Portishead Branch Line (MetroWest Phase 1)

Planning Inspectorate Reference: TR040011

9.3.1 ExA.SoCG-NSC.D7.V2 – Statement of Common Ground

Date: April 2021

Drawing
PORTISHEAD STATION CAR PARK
LAYOUT, LANDSCAPING AND NEW
BOULEVARD AND ACCESS PLAN
SHEET 2 OF 3

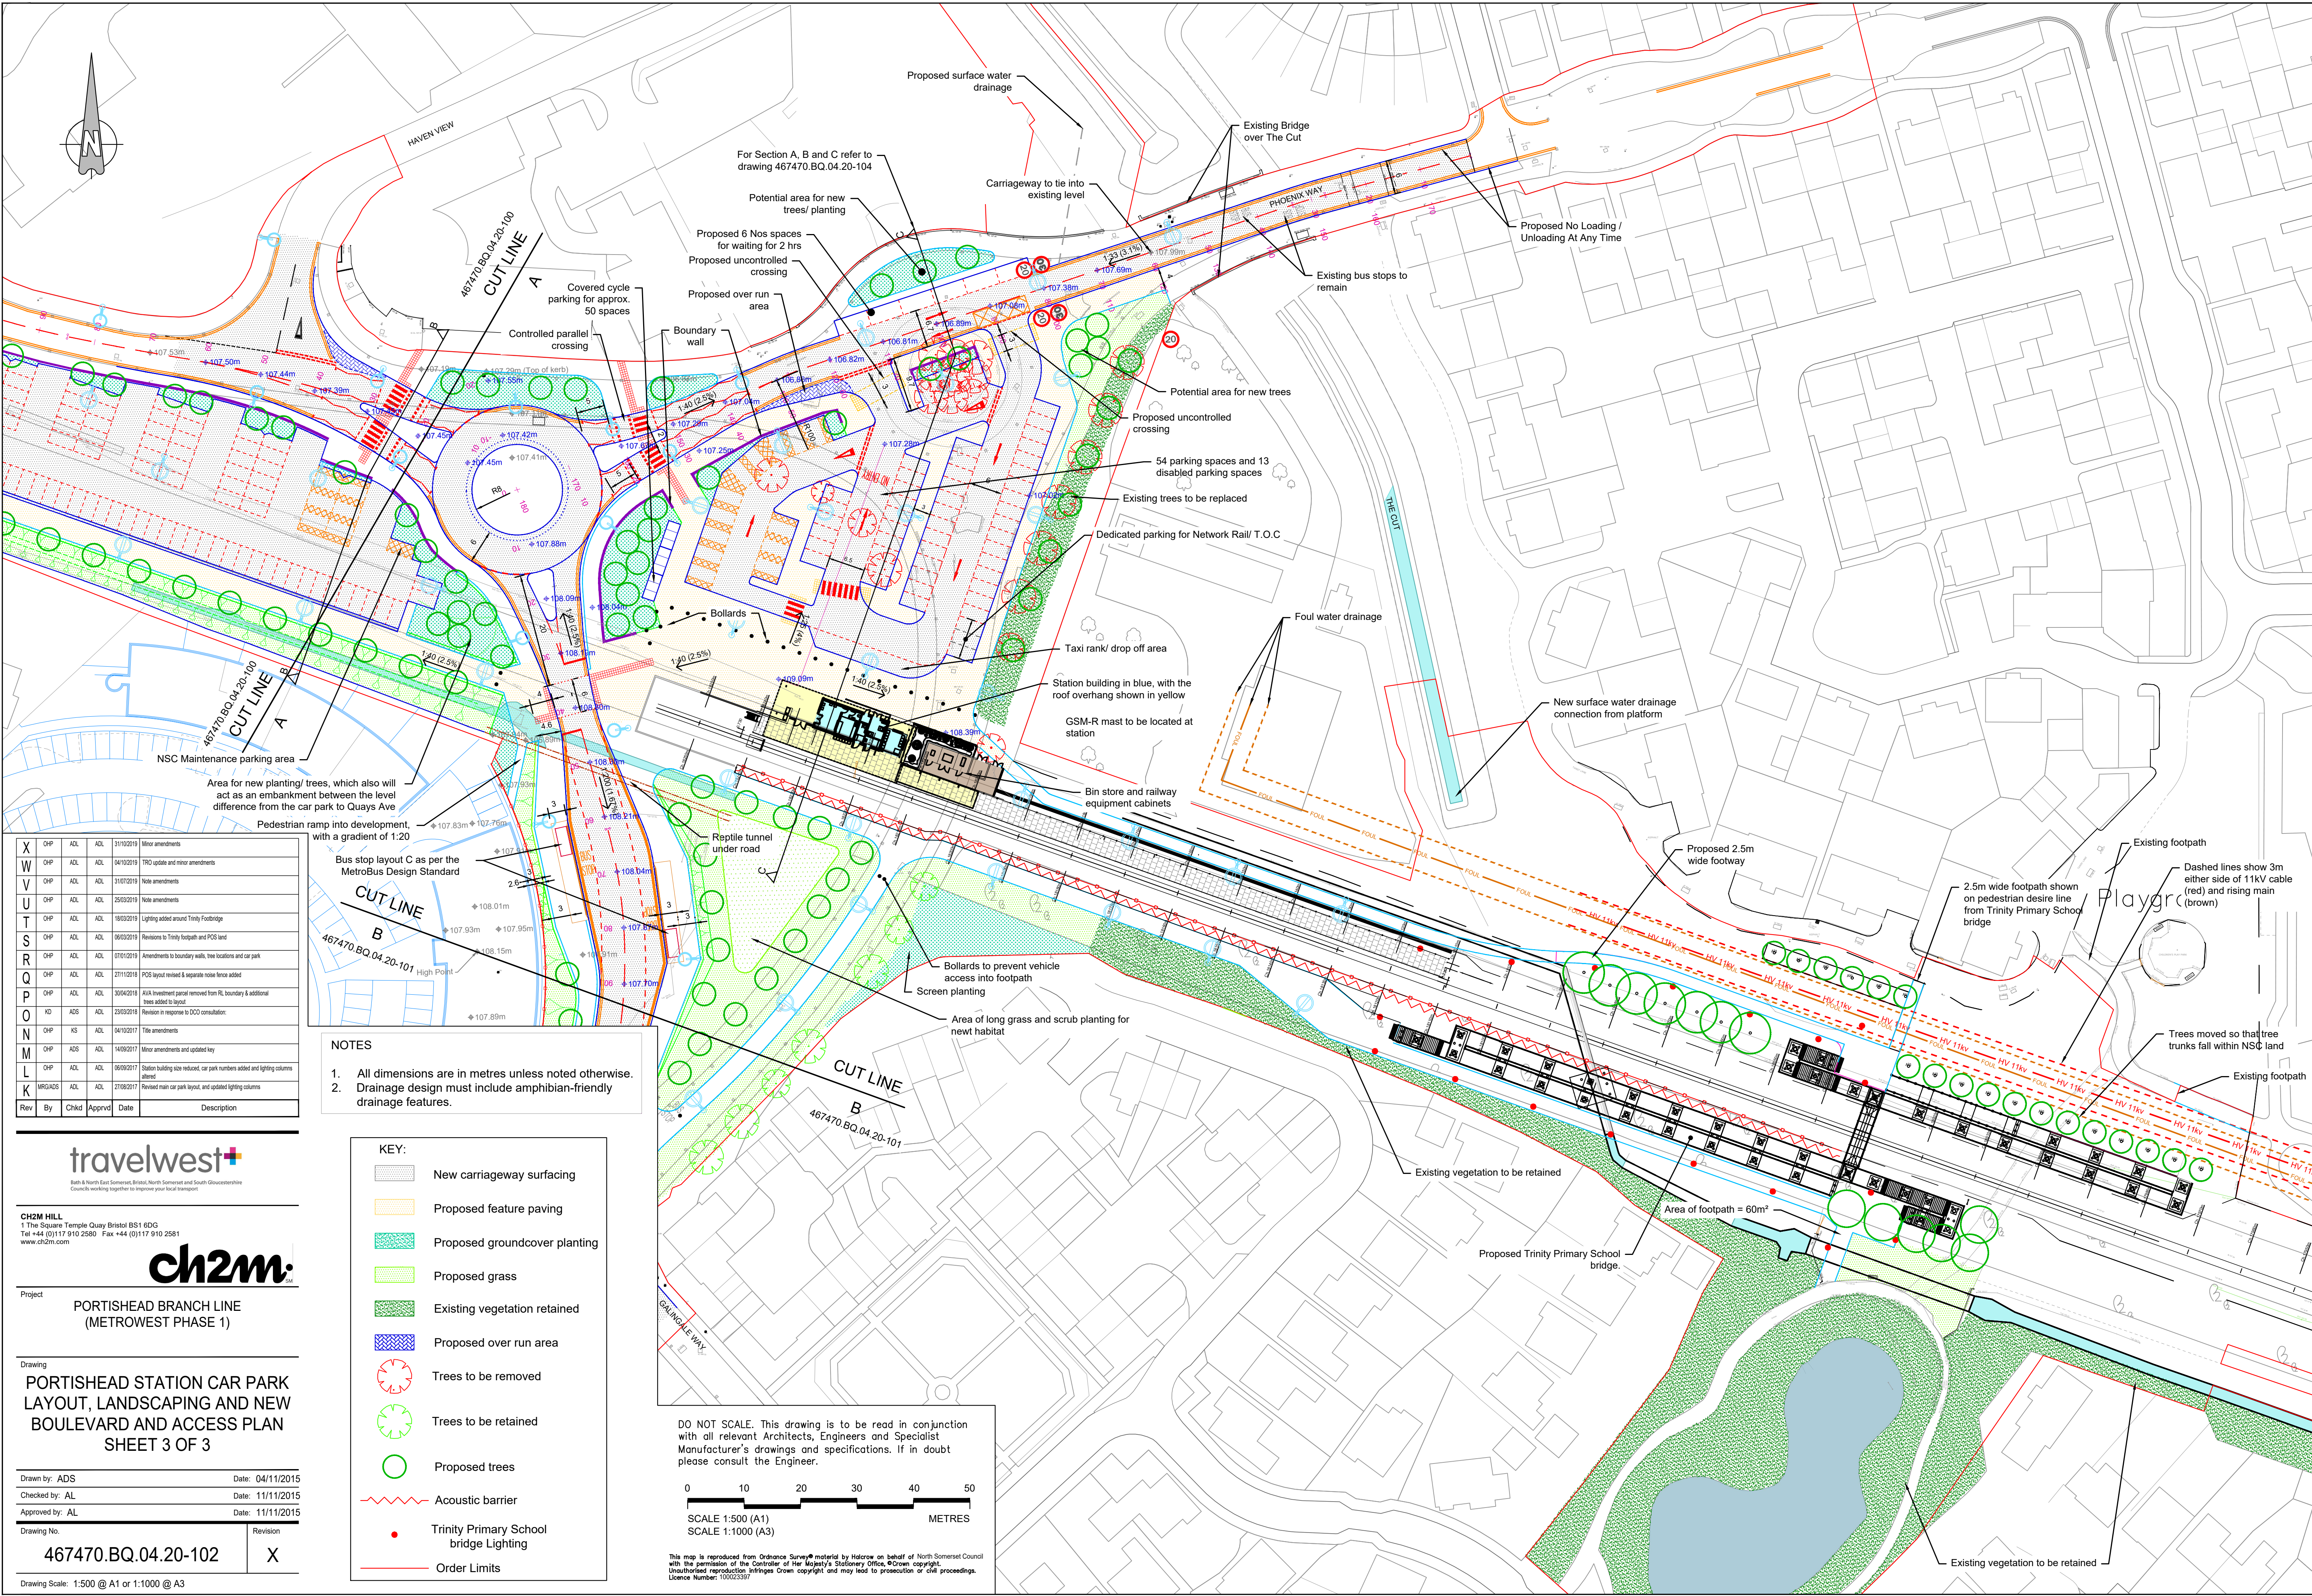
- (a) Requested 14 days' notice before the end of the 8 week approval period prior to deemed consent of Requirements (as set out in Schedule 2 of the dDCO taking effect;
- (b) Requested further detail on how the larger car park access at the junction with Harbour Road and Papermill Gardens will operate. The proposed operation of

this junction will be tested to demonstrate that it will operate satisfactorily at the detailed design stage;

2.42 - Pill Station Car Park and PSP Layout, Landscaping Lighting and Access Plan

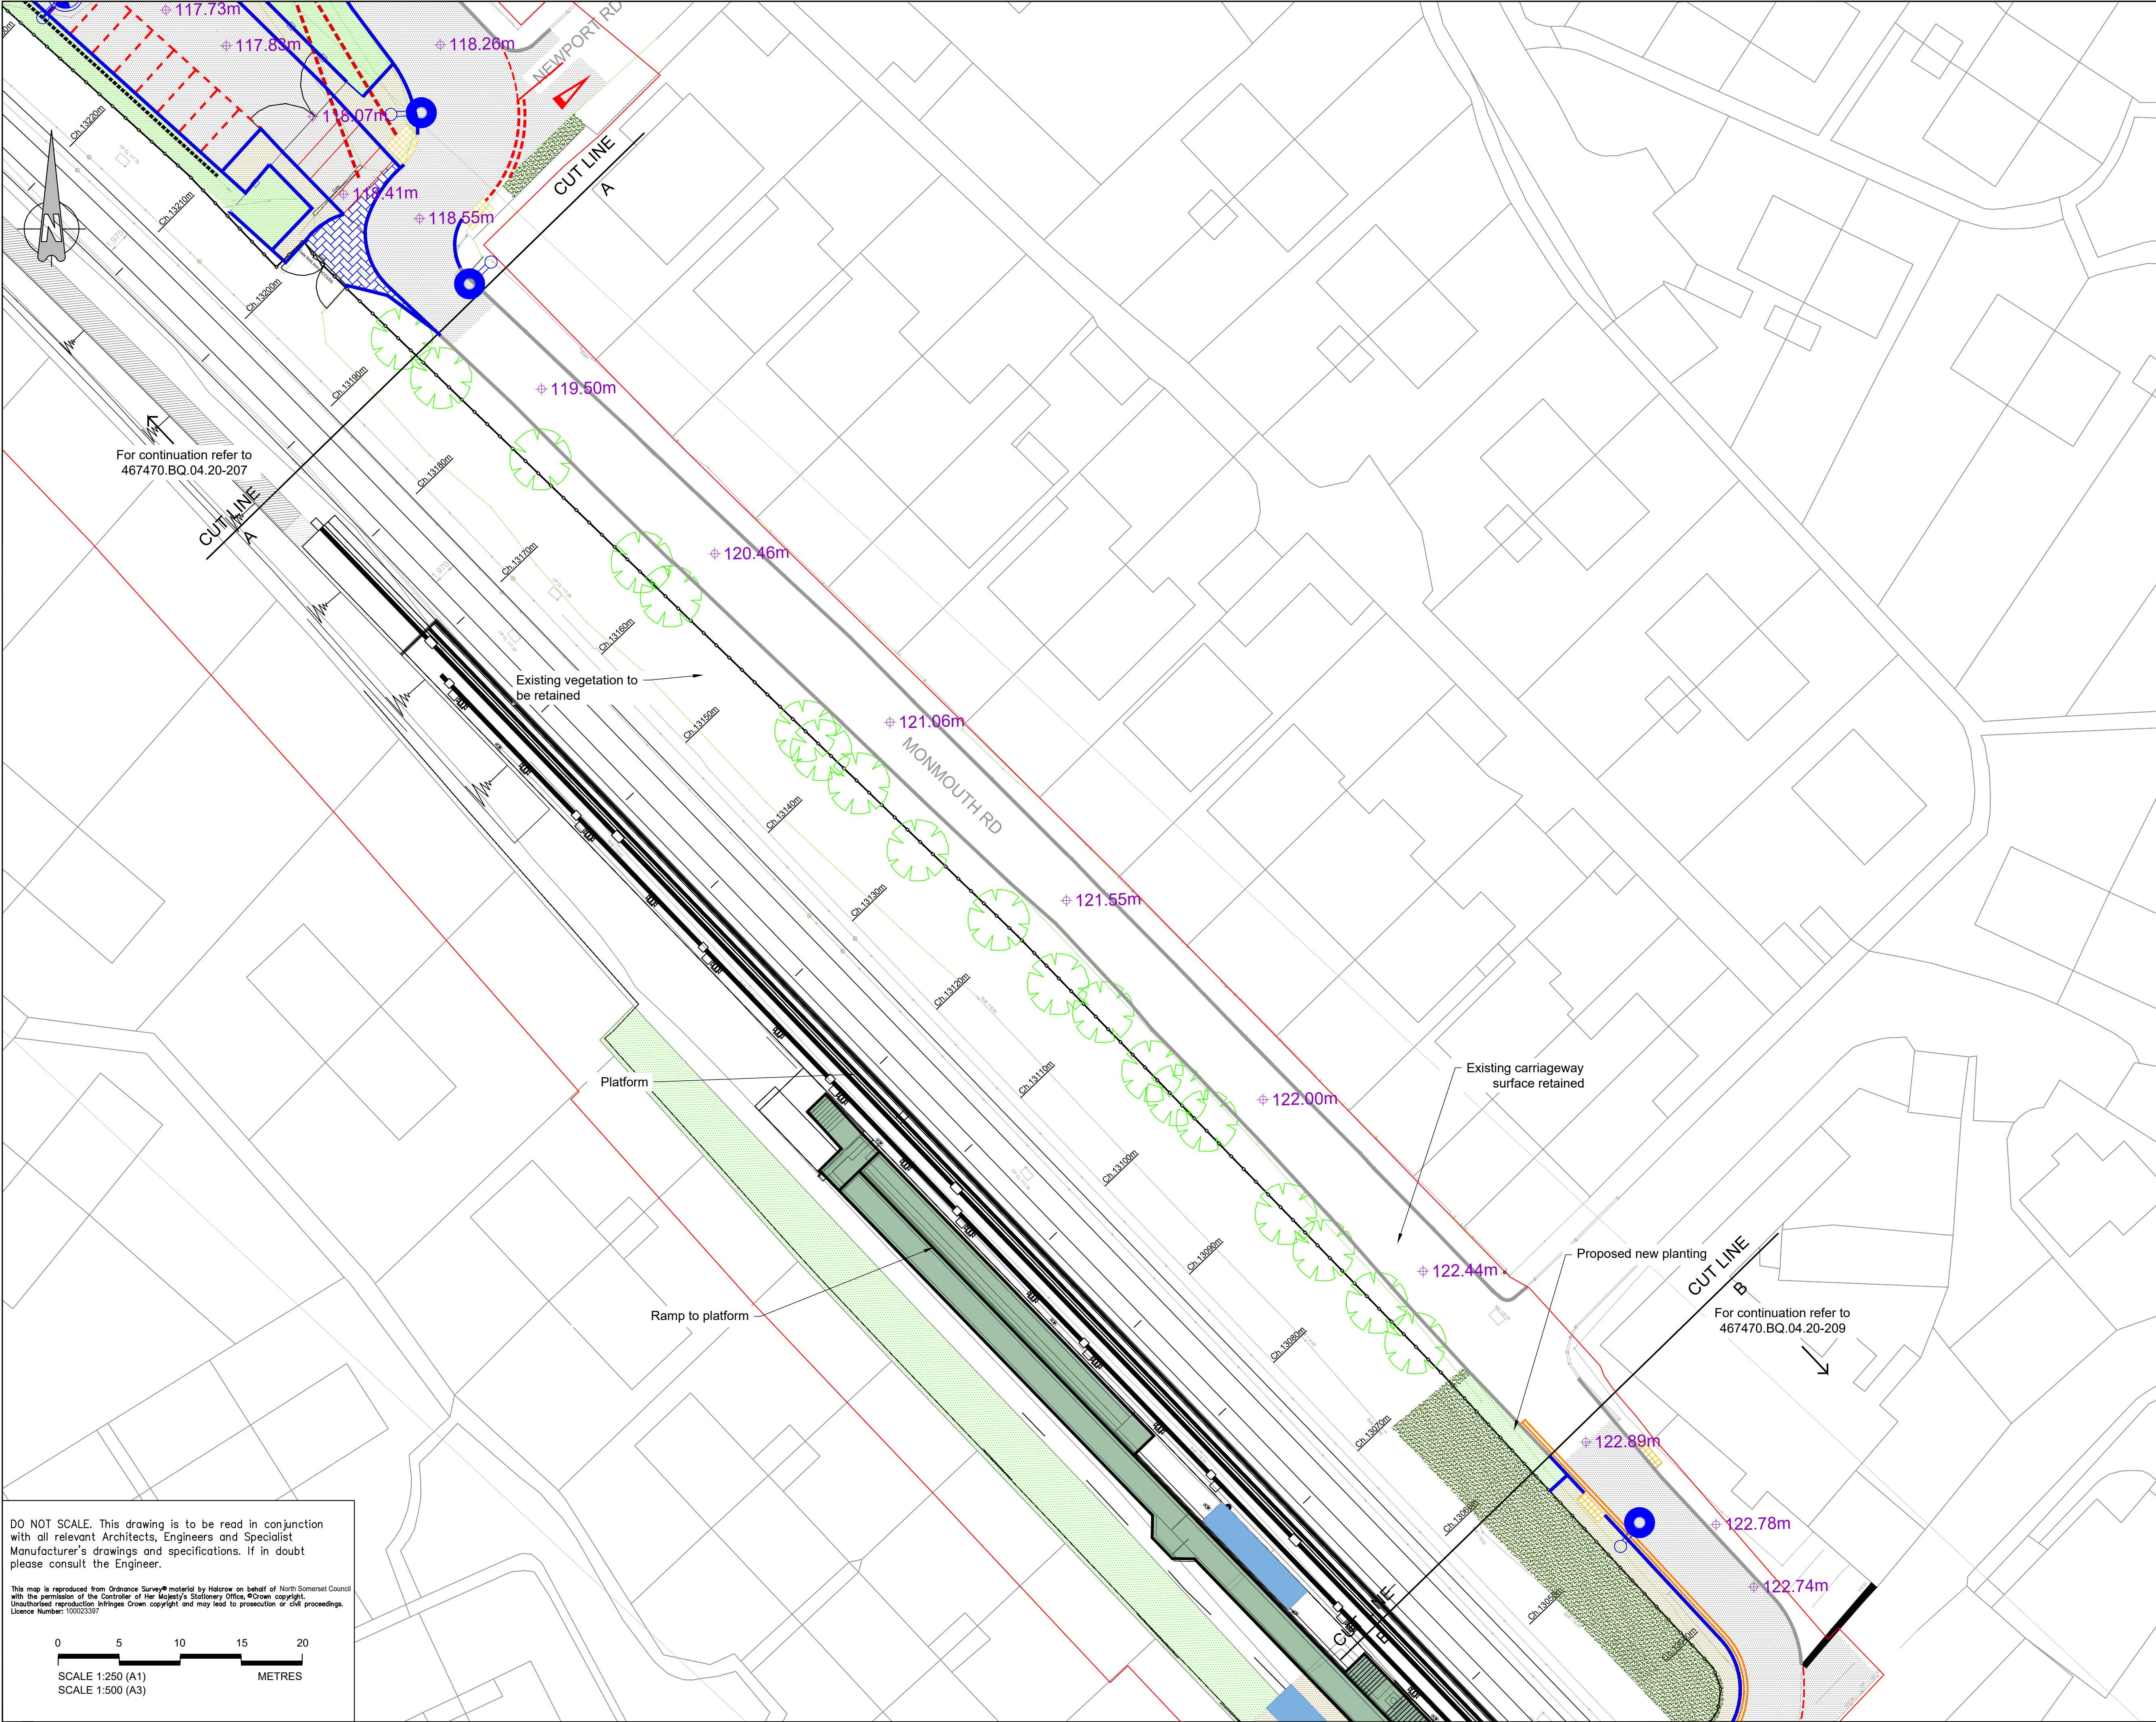
Ref.	Topic	LPA position	Applicant position	Status (Agreed/ Not Agreed)
8.1.1	Pill Station – design (Consultation)	The finish on the vertical wall at Pill Station could have texturing to it rather than be smooth concrete.	It was agreed to engage further with the LPA at the detailed design stage.	Agreed. The LPA's preference is noted, and both parties agree points concerning detailed design will be addressed collaboratively post-DCO.

8.1.2	Pill Station – bats (Consultation)	Concerns regarding the impacts from lighting upgrades to the bat roost at Pill Station. The LPA requests a constraints plan for the site, showing the areas of the roost and any identified horseshoe bat commuting route(s) that must be retained unlit (at or below 0.5lux) that could be provided to the station lighting design team to inform the site lighting constraints for the lighting design. If this is not feasible due to the wide-reaching operational lighting requirements of the station, it needs to be considered if an alternative roost provision can be provided within a suitable location in proximity.	Bat surveys revealed a presence around Pill Station. Work to assess and provide mitigation for the operational lighting impacts has been undertaken and is detailed in Section 9.6 of ES Chapter 9 – Ecology and Biodiversity (DCO Document Reference 6.12, Examination Library ref APP-208) with the survey reports in the Bat Technical Appendix (ES Appendix 9.2, DCO Document Reference 6.25, Examination Library ref AS-036). Examples of mitigations proposed include a barrier or modifications to the lighting design. These will be determined at the detailed design stage.	Agreed. In principle the deferral of the detailed measures until a later detailed design stage is acceptable. It is understood that licensing is likely to be required for this proposal. With the licensing process, to be carried out by Natural England, and further consultation at the detailed design stage there is adequate

Ref.	Topic	LPA position	Applicant position	Status (Agreed/ Not Agreed)
8.1.3	Pill Station – highway drainage (Consultation)	Request checks take place at Pill Station car park as there are existing problems with the highway drainage network in the area, particularly with tide lock, which will require a capacity check and improvement of the system to adoptable standards.	<p>The existing highway drainage system has been surveyed to check its condition and capacity as detailed in Section 6.6.6 of the Surface Water Drainage Strategy for Portishead and Pill Stations, Haul Roads and Compounds (DCO Document Reference 6.26, Examination Library ref APP-192). The highway drainage survey reports have been issued to the Local Highway Authority and the information used to develop a proposed outline design for the drainage of Pill Station. The Pill Station Drainage Report (issued to the Local Highway Authority in February 2020) sets out the proposed route, capacity, outfalls and flow rates.</p> <p>The proposed solution will be developed further at the detailed design stage and subject to approval from the LPA.</p>	<p>opportunity to resolve this.</p> <p>Agreed.</p> <p>The proposed approach is agreed and outline designs are being developed in accordance with this.</p> <p>Detailed designs (performance modelling, implementation and maintenance details), will need to be submitted and approved by the LPA as set out in Requirement 11 of the dDCO.</p>
